Our ref: DOC19/1000939

Senders ref: SSD 10366

Subject: Exhibition of EIS – Bunnings Warehouse Leppington located at Lot 3 Bringelly Road Business Hub, Bringelly Road, Leppington (SSD-10366) (Liverpool City)

Initially proposed landscape design for car park

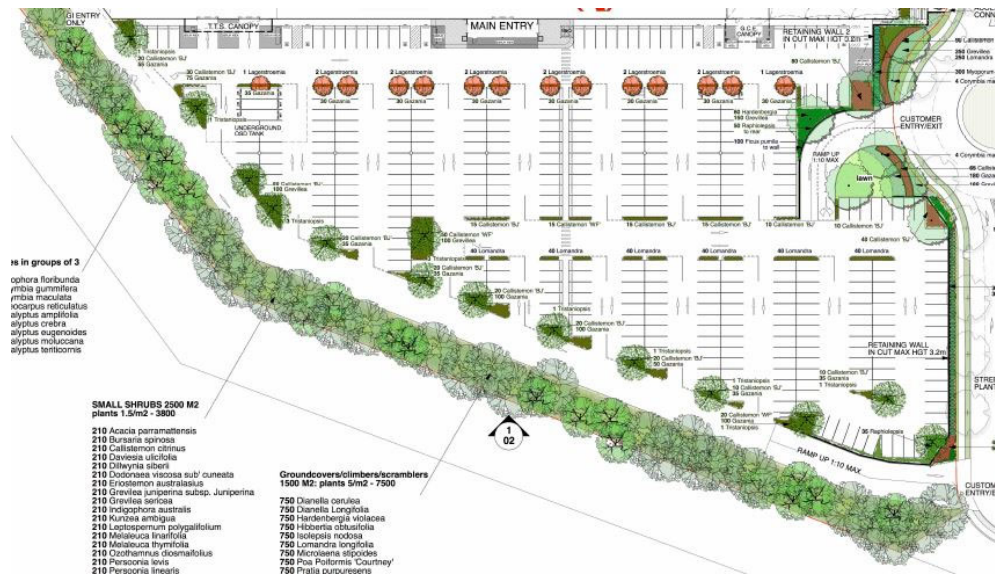
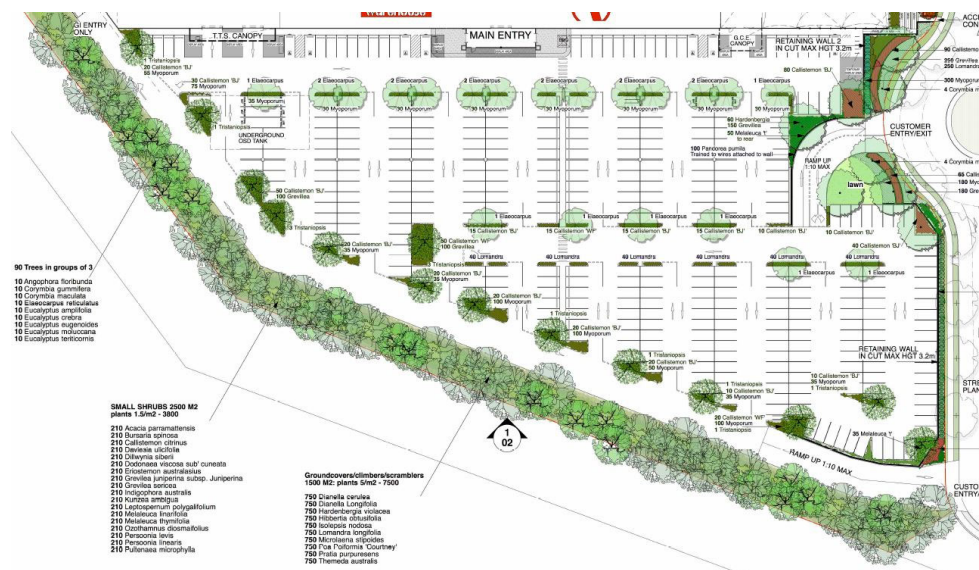
The Landscape Plan proposes to use species that are not native to the area. This is despite the Notice of Determination for the Concept plan requiring (Conditions B4 and B5) that native plants and species indigenous to the area be used. EES recommends that the landscape plan be amended to use native plants indigenous to the area.
